**58 Torrey Street - Building Permit #2016-01206**

I have completed my initial zoning review for this permit. I need more information before I can sign off and move the permit forward in the system.

Proposed Roof Rafter
layout

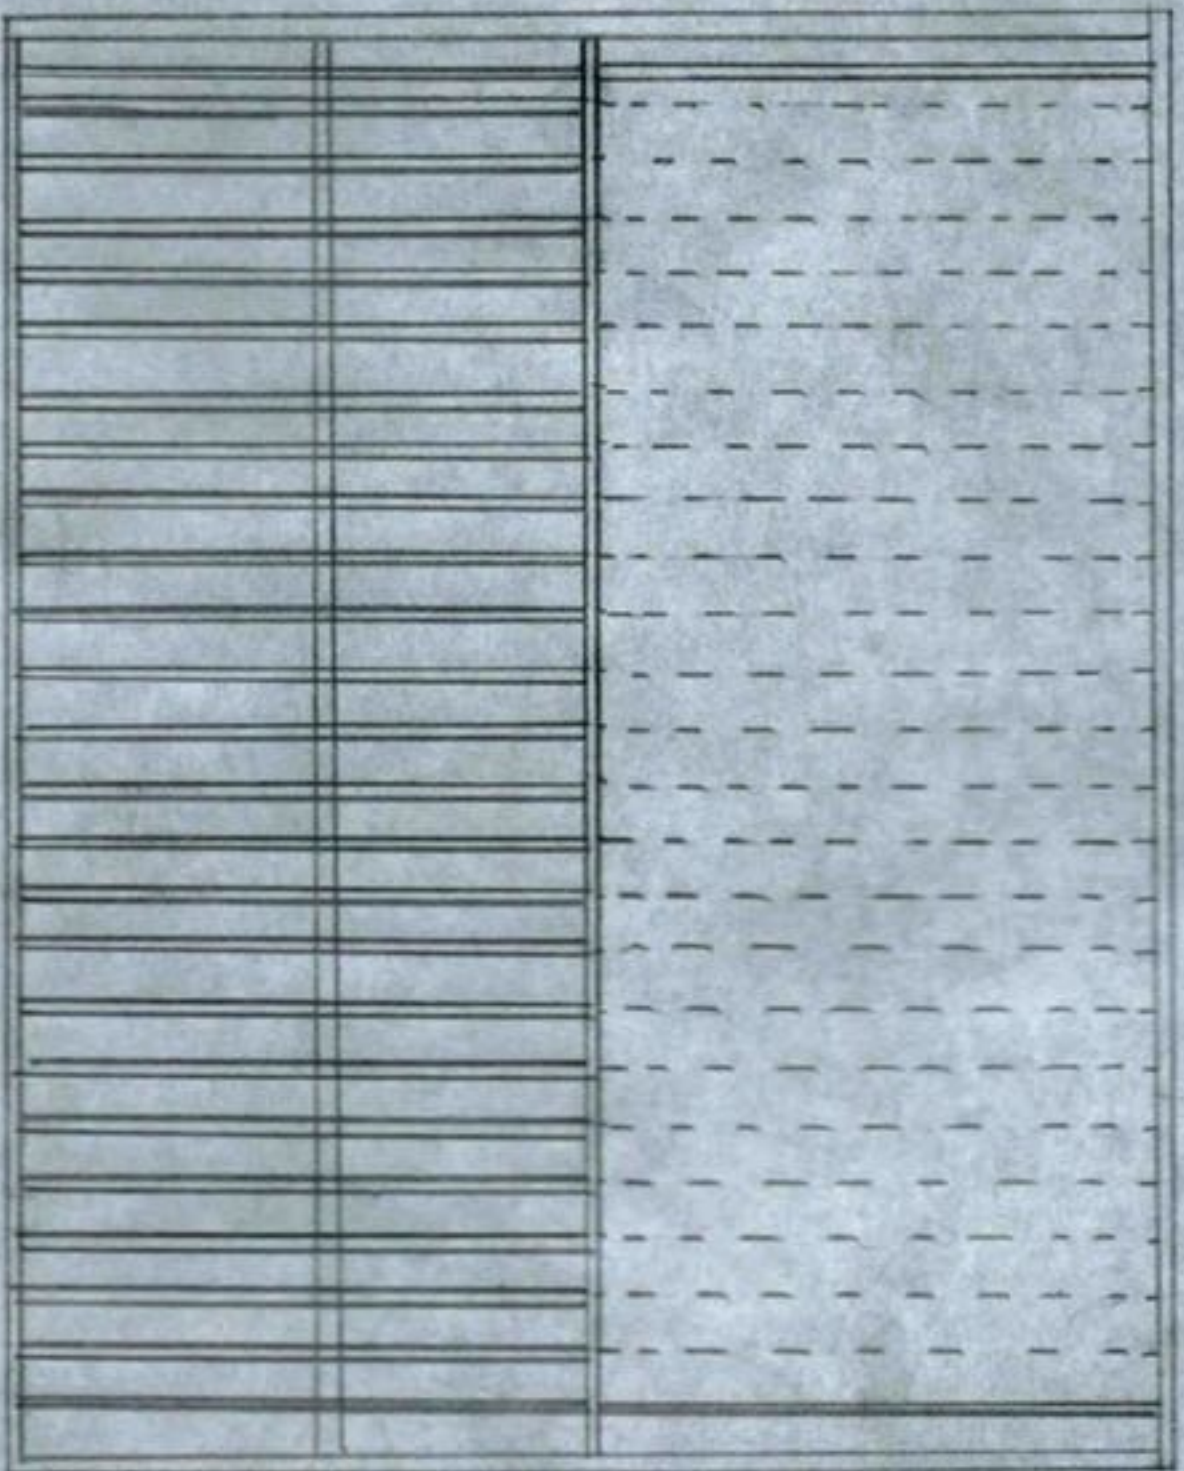
1. What is the length of the dormer?
2. You need to submit a plot plan. A dormer is an addition, so I need to know what the setbacks are.

Hello again, I will be filing an amendment and will include setback information there. The original dormer was 10' long, the new concept is 28' full length dormer. I'll get you all of the information asap.
